SUBJECT: Engineering Review Comment  
Mountain View Electric Association Inc. (MVEA)

**Project Name: Settlers Ranch Filing 3 – Final Plat**

**Project Number: SF249**

**Description:** A proposed development of 24 lots and 1 tract located east of Settlers Ranch Rd and north of Hodgen Rd. in Township 11S, Range 66W, Sections 23 and 24.

P.O. Box 5101 Woodland Park, CO. 80866 (719) 687-0920

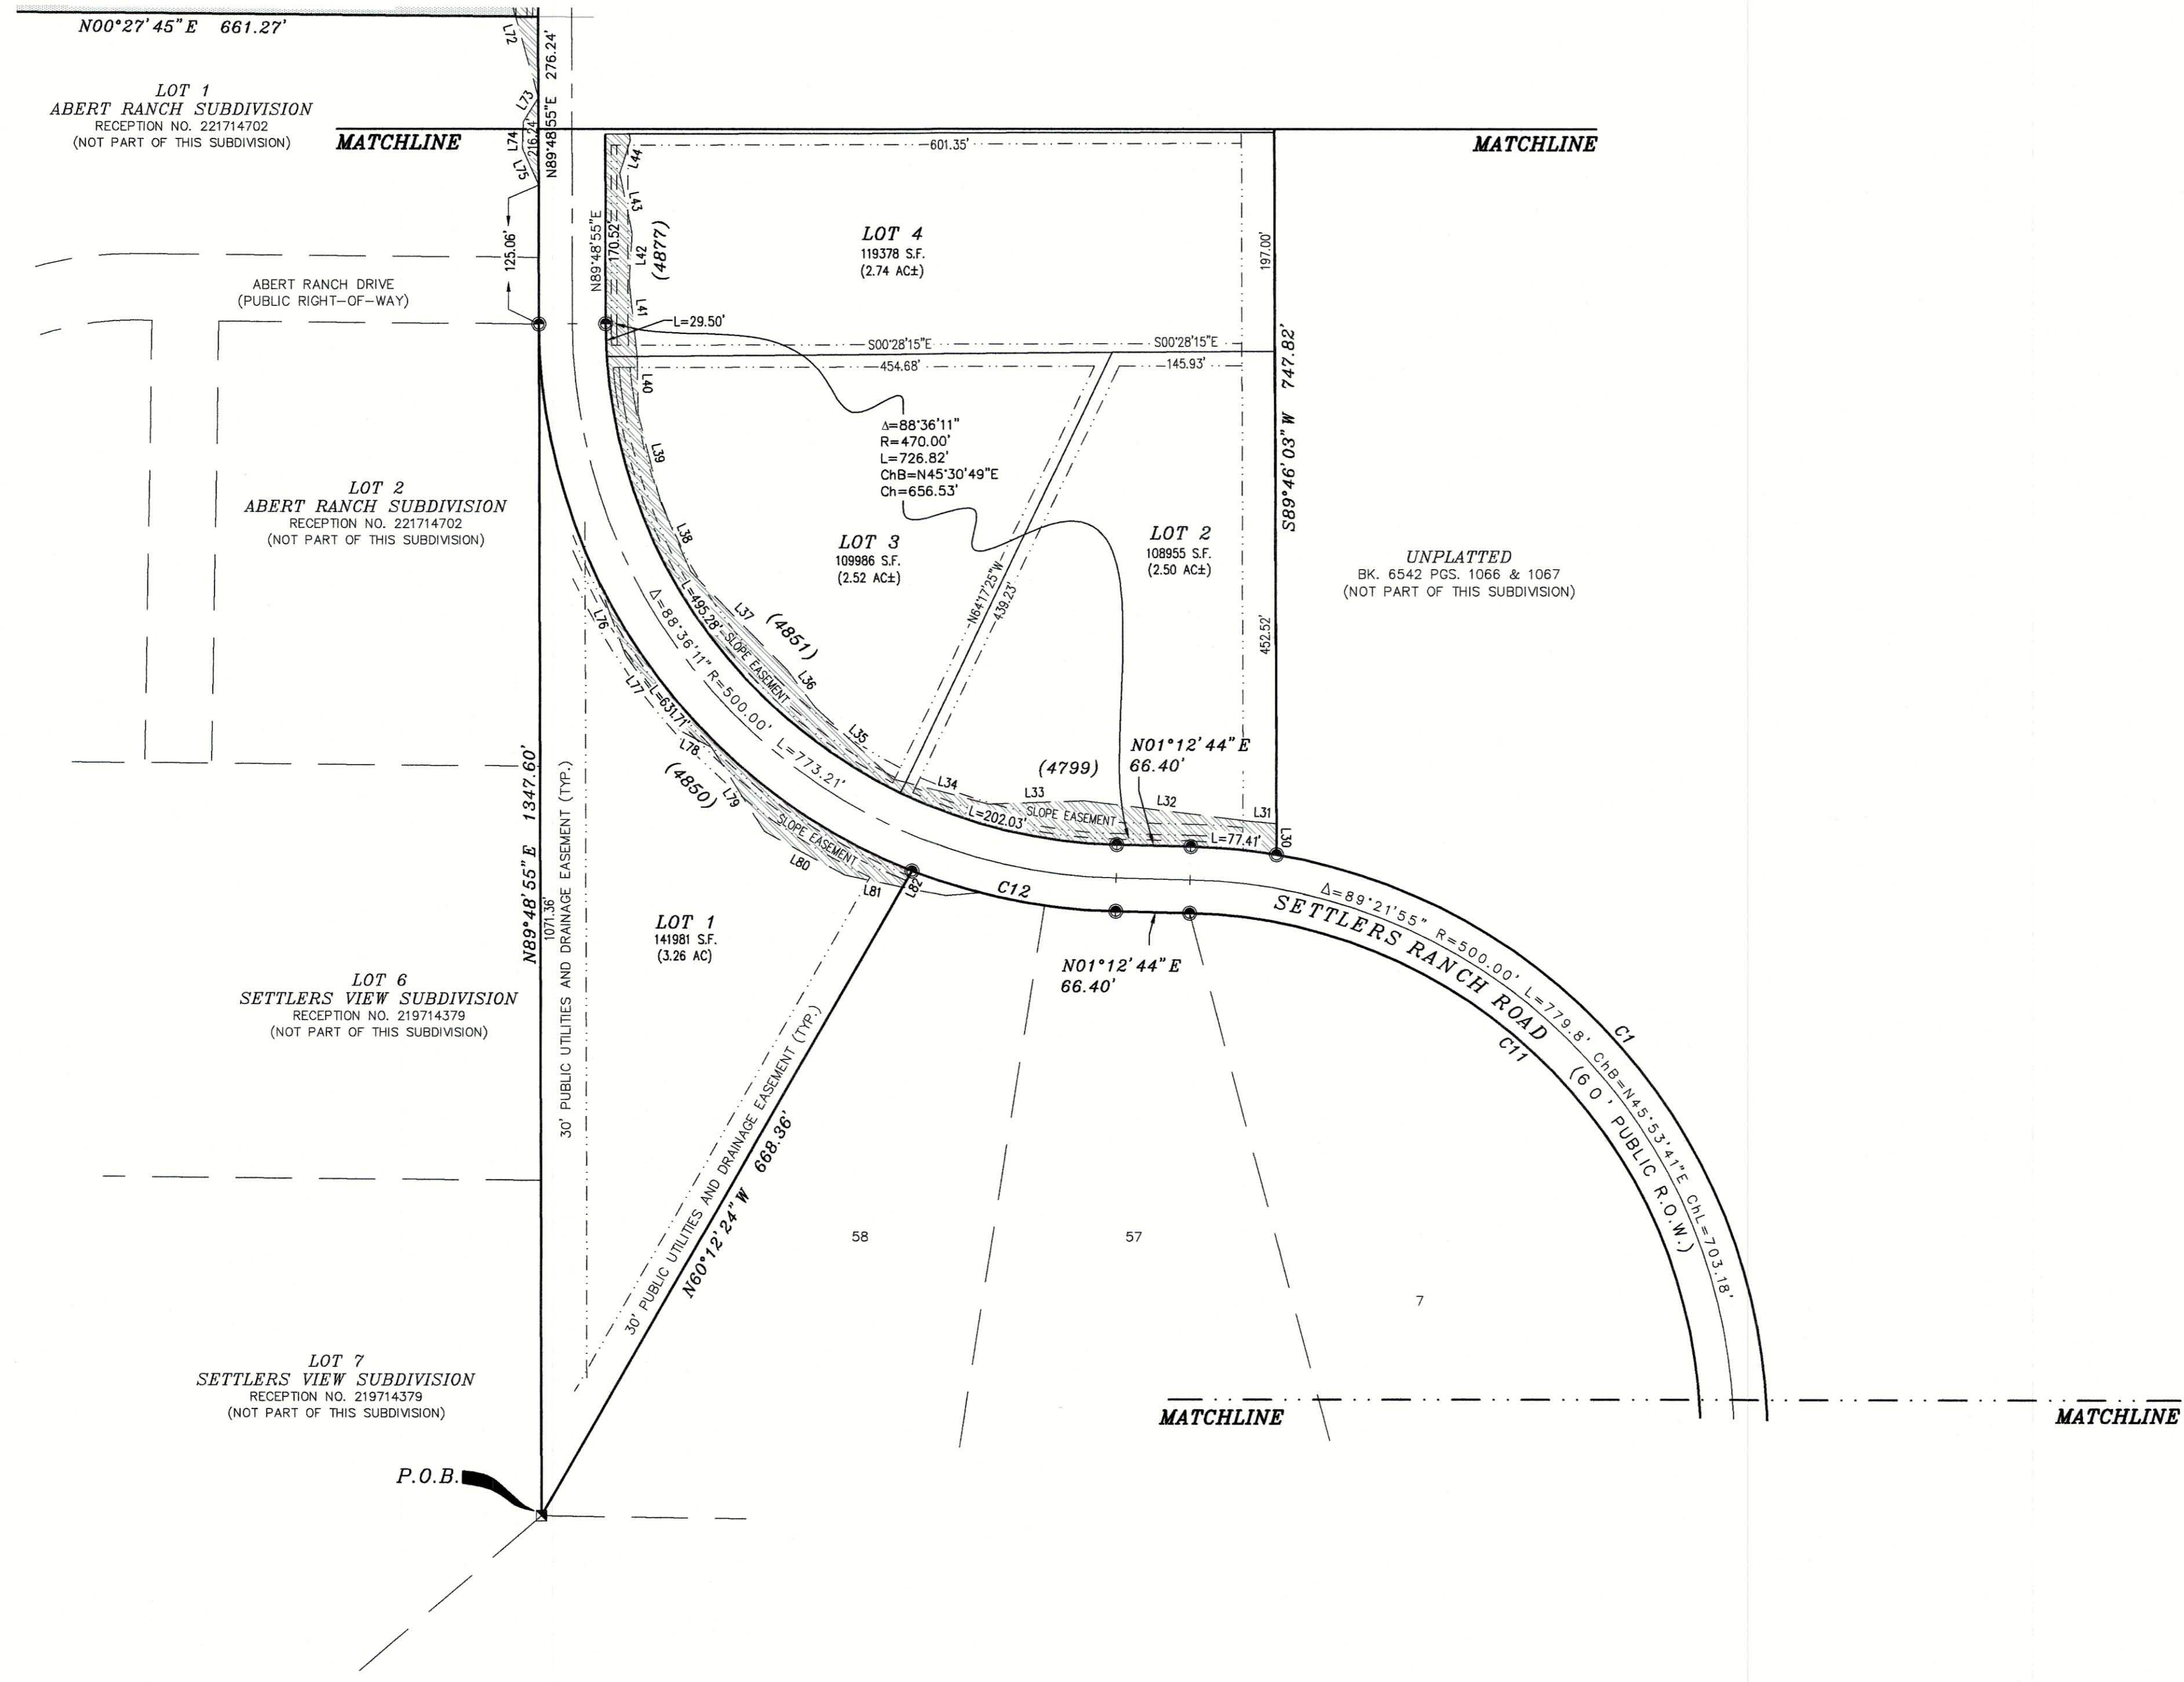
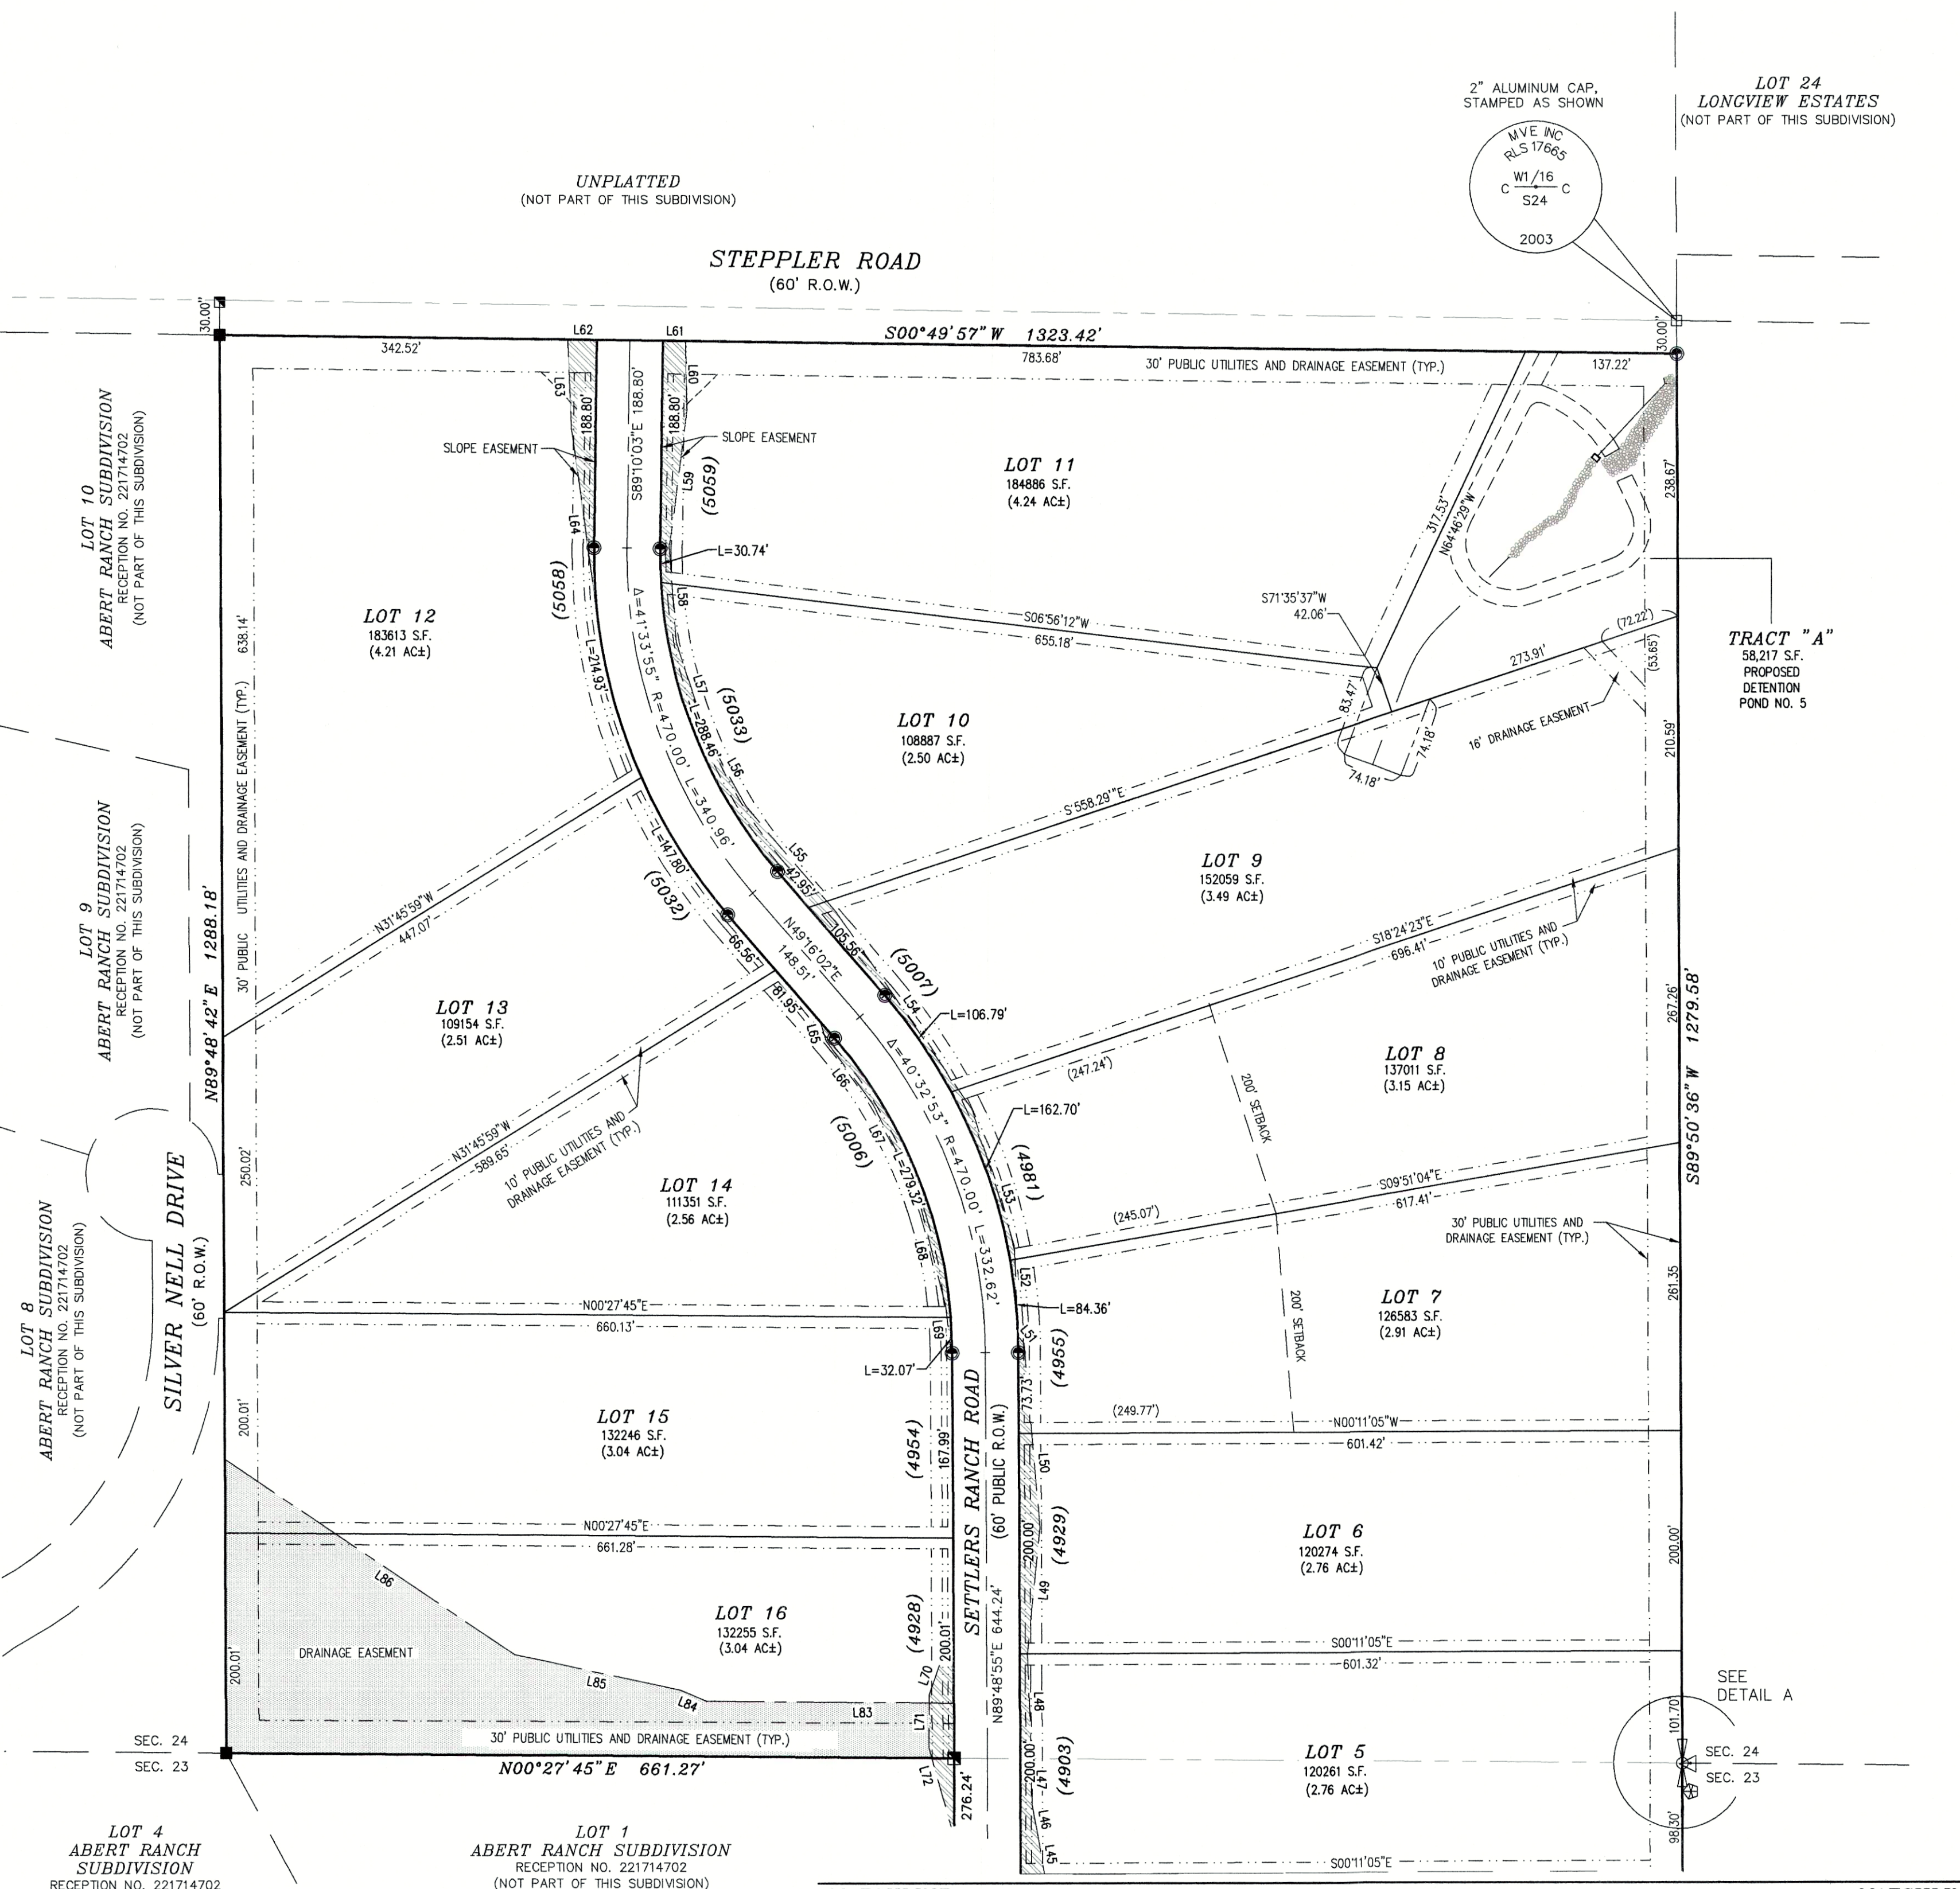
MVEA requests a ten (10) foot front, side, and rear lot utility easement and all tracts, along with a twenty (20) foot exterior utility easement on the plat. MVEA also requests the platting of MVEA's existing facilities with easements on the plat. Additional easements may be required.
